Item No. Report of the Head of Planning, Sport and Green Spaces**Address** PINKWELL PRIMARY SCHOOL PINKWELL LANE HAYES**Development:** Non-material amendment to planning permission ref: 11242/APP/2012/3116 dated 08/03/13 (expansion of school to include stand alone classroom block and extended nursery, staff room, reception, library and classrooms with associated car parking and landscaping) to make changes to the external finishes of the nursery extension.**LBH Ref Nos:** **11242/APP/2014/2637****Drawing Nos:** 7555 D PL600 (Elevations)
2 x photographs of nursery**Date Plans received :** 14/07/2014**Date(s) of Amendment(s):****Date Application Valid:** 14/07/2014**1. DETAILS**

This application seeks a non-material amendment to the approved scheme to alter previously proposed brick work to the nursery building extension to white render. The applicant has advised that the reason for the change is due to the lead in time associated with bricks to match the existing building and the need to complete the building within programme.

FOR APPROVAL			
ARCHITYPE			
London t 020 7403 2889 Hereford t 01981 542 111			
Project	7555 Pinkwell Primary School		
Client	London Borough of Hillingdon		
Dwg Title	Elevations		
Dwg no.	7555 D	PL600	Revision
Scale	1 : 50 @ A1	Date	11 July 14
Drawn by	PU	Checked by	LF

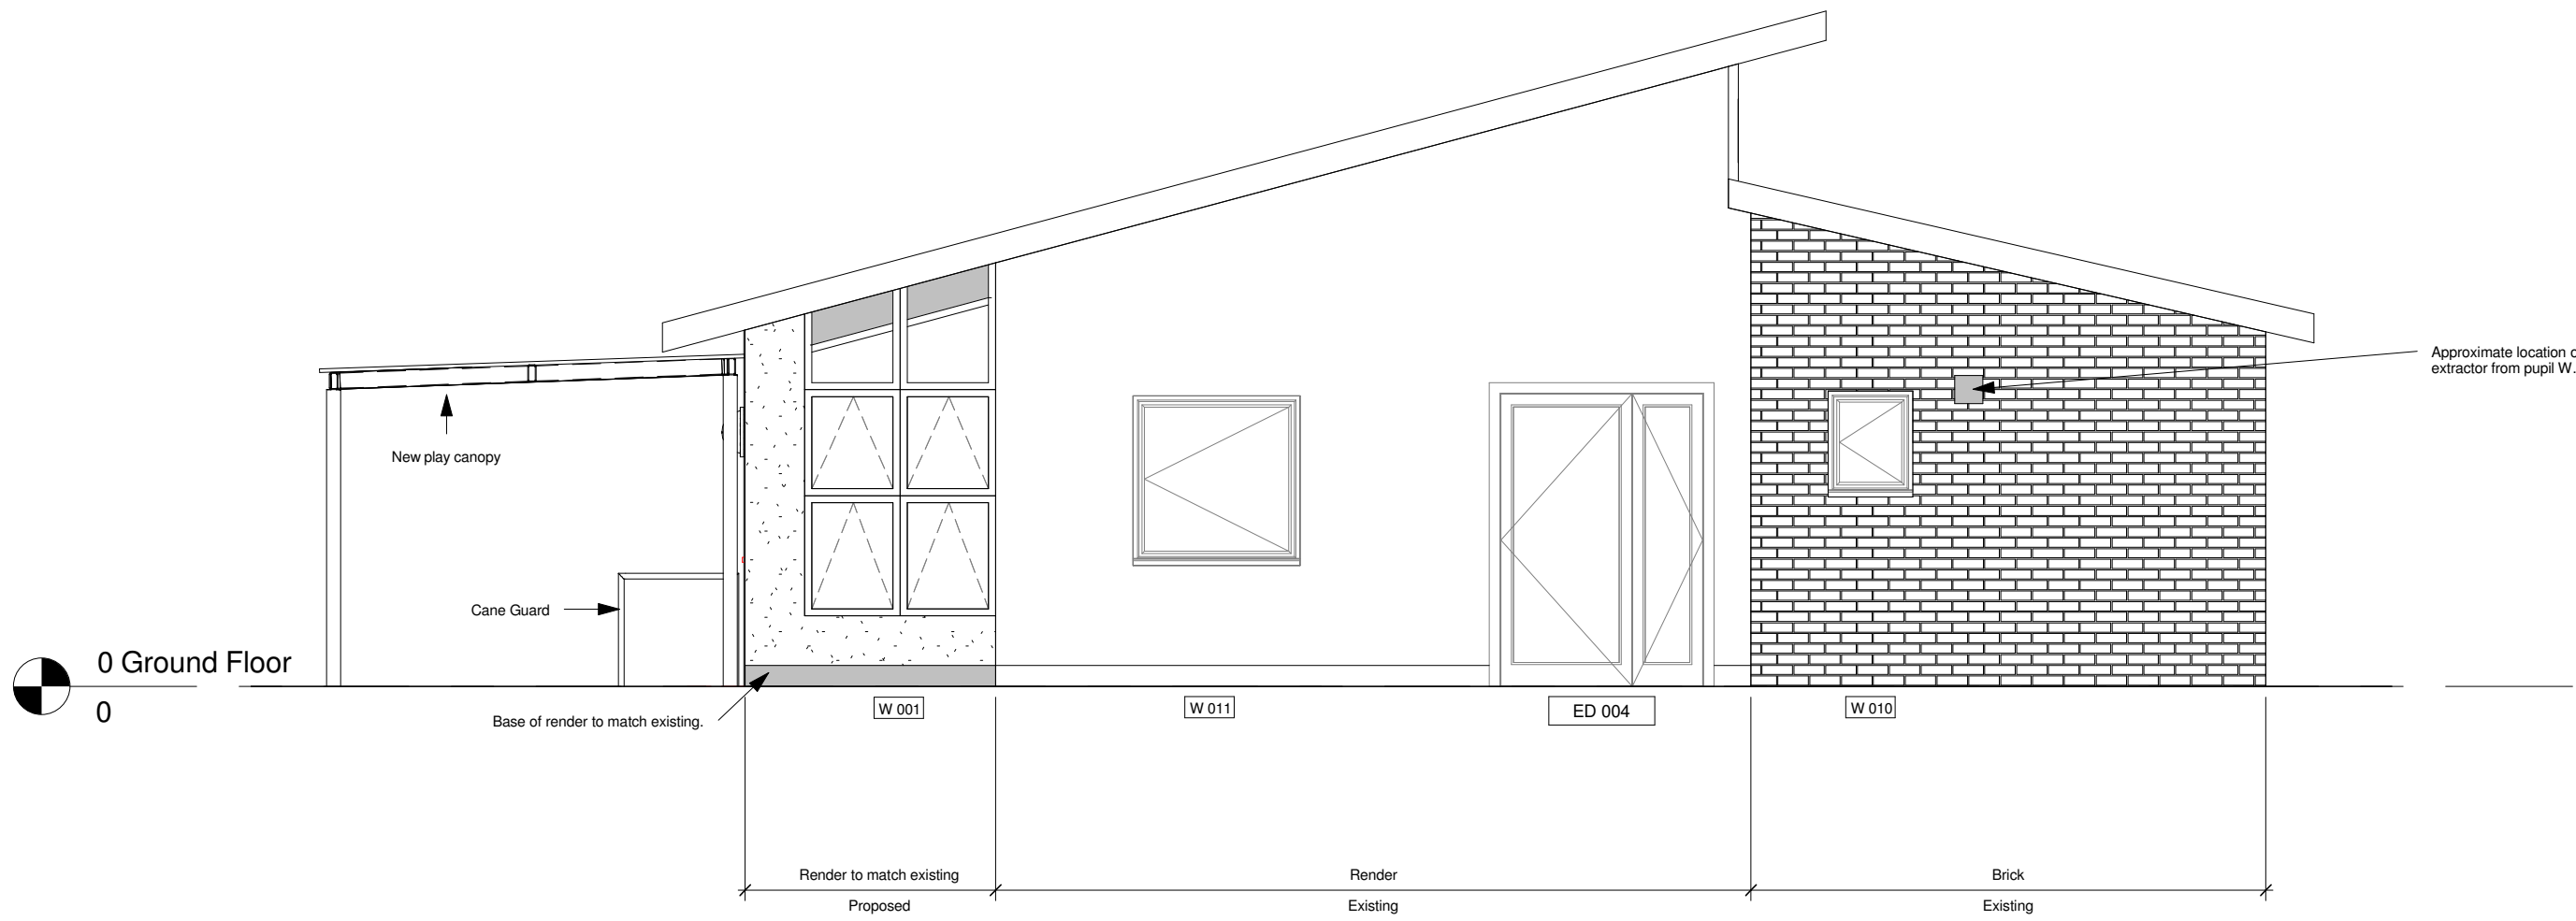
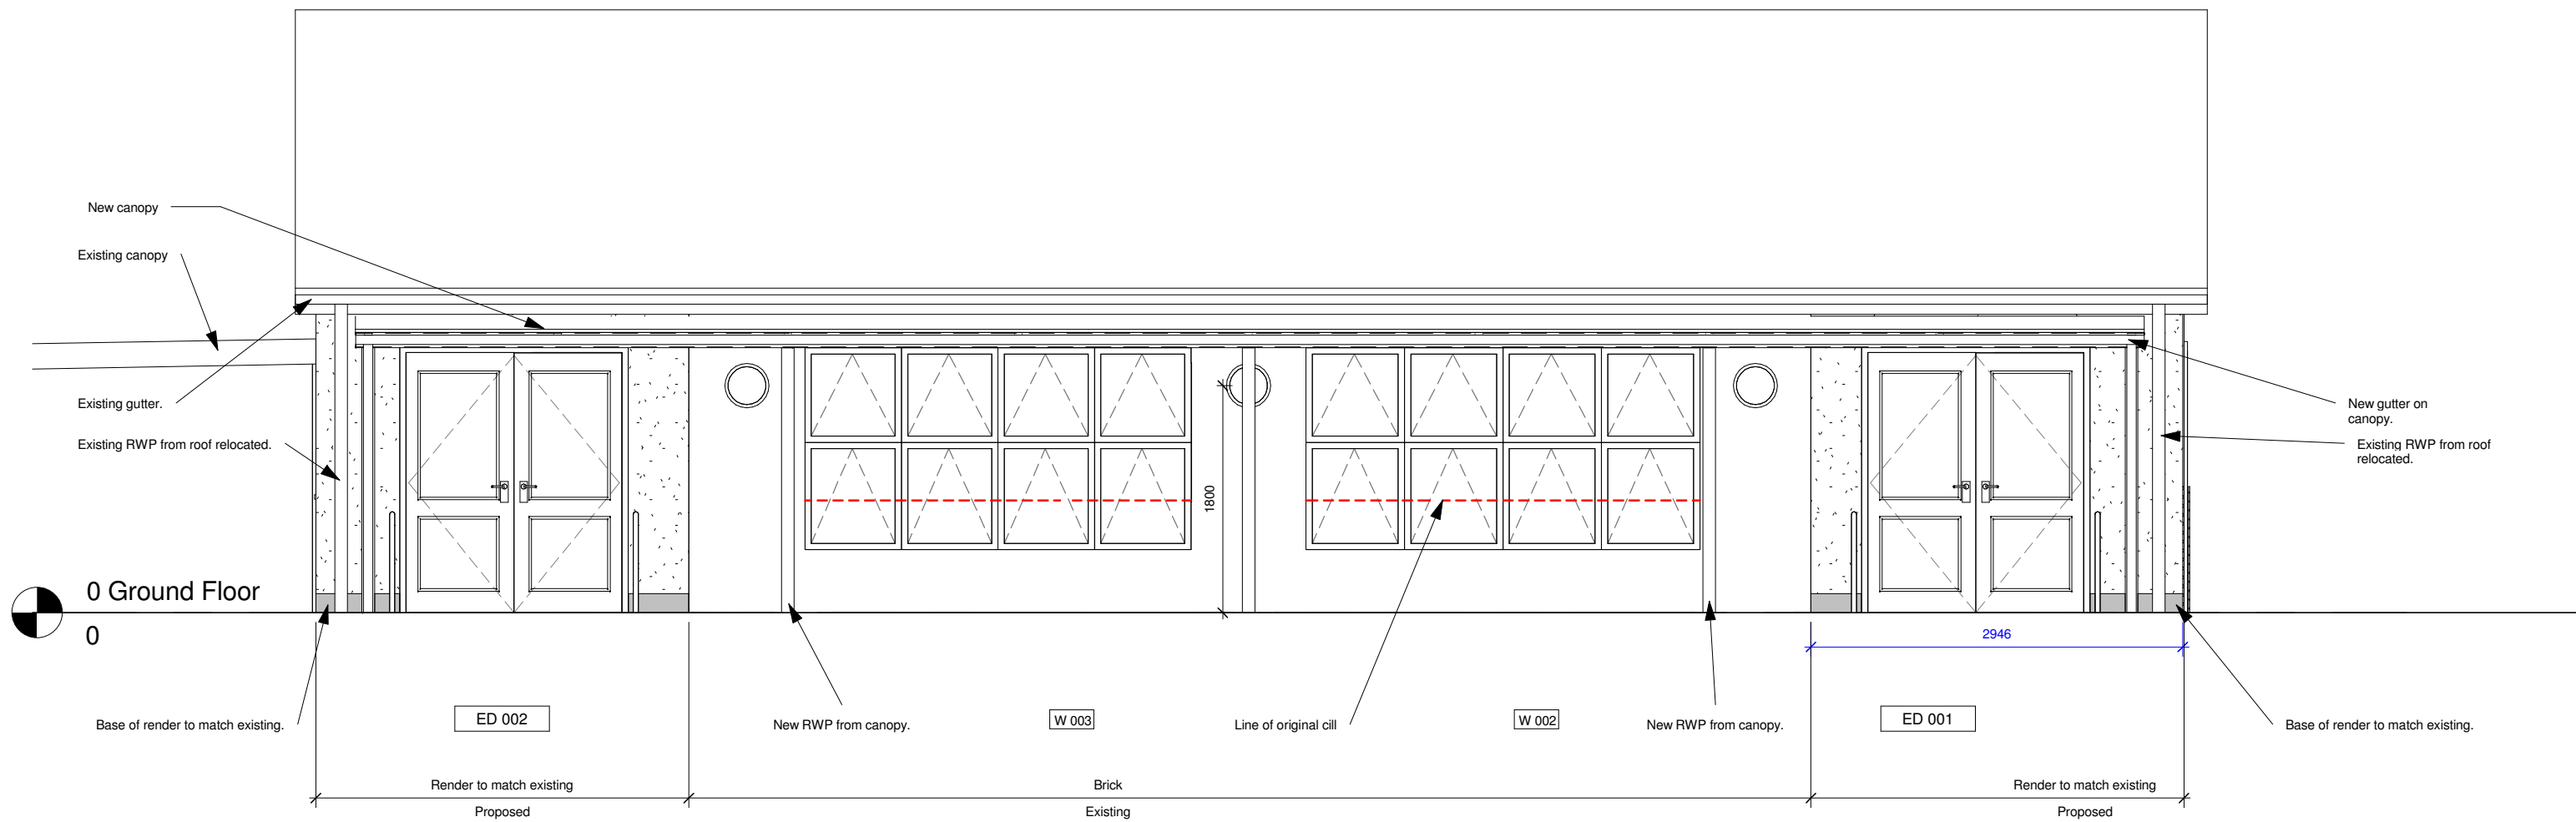
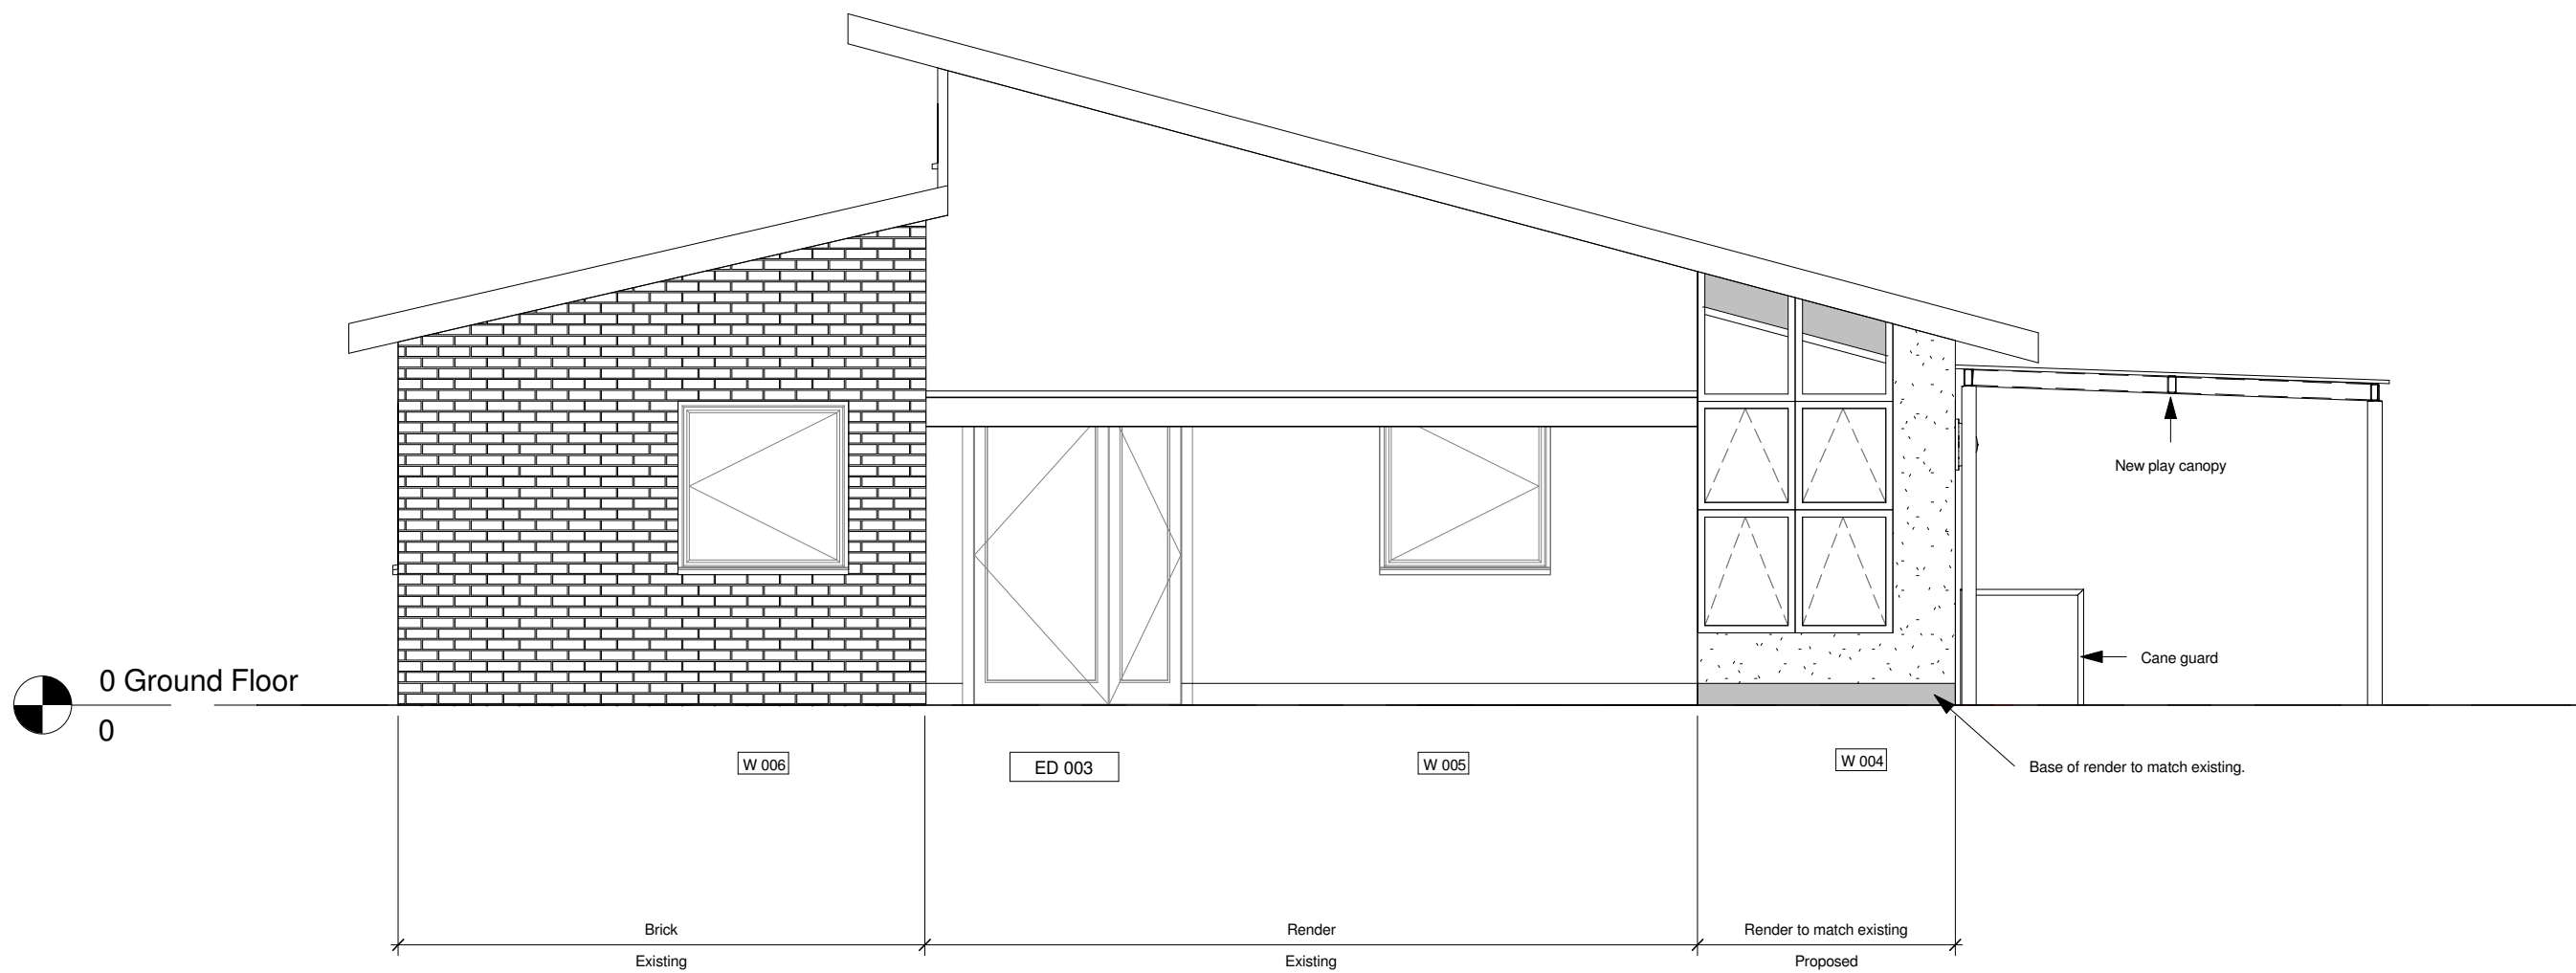
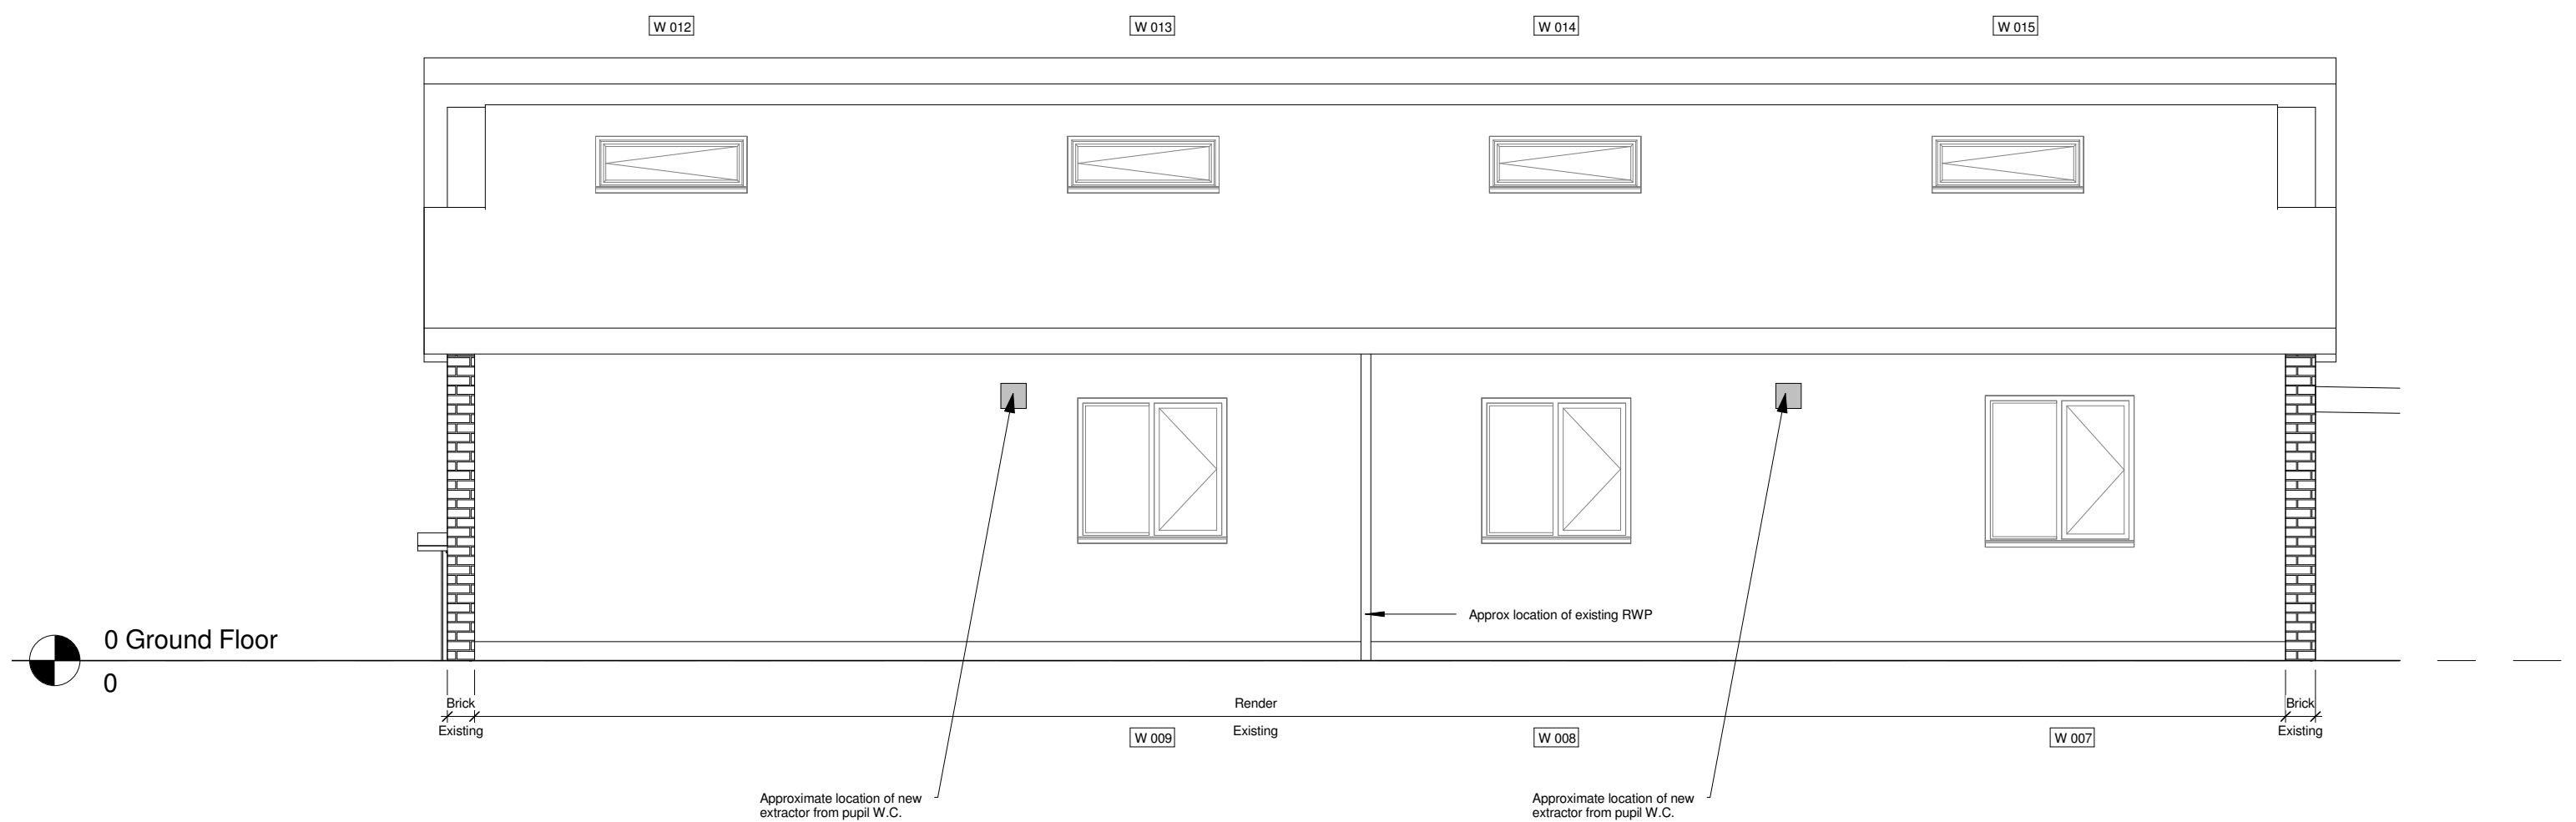
The works have already been carried out and elevational drawings and photographs have been provided. The use of white render in place of brick work represents a relatively minor change and is considered to be visually acceptable in this instance.

In conclusion, in view of the limited resulting visual impact of the alterations on the wider school site and surrounding area, it is recommended that they are approved as non-material minor amendments to planning permission ref: 11242/APP/2012/3116 dated 08/08/13.
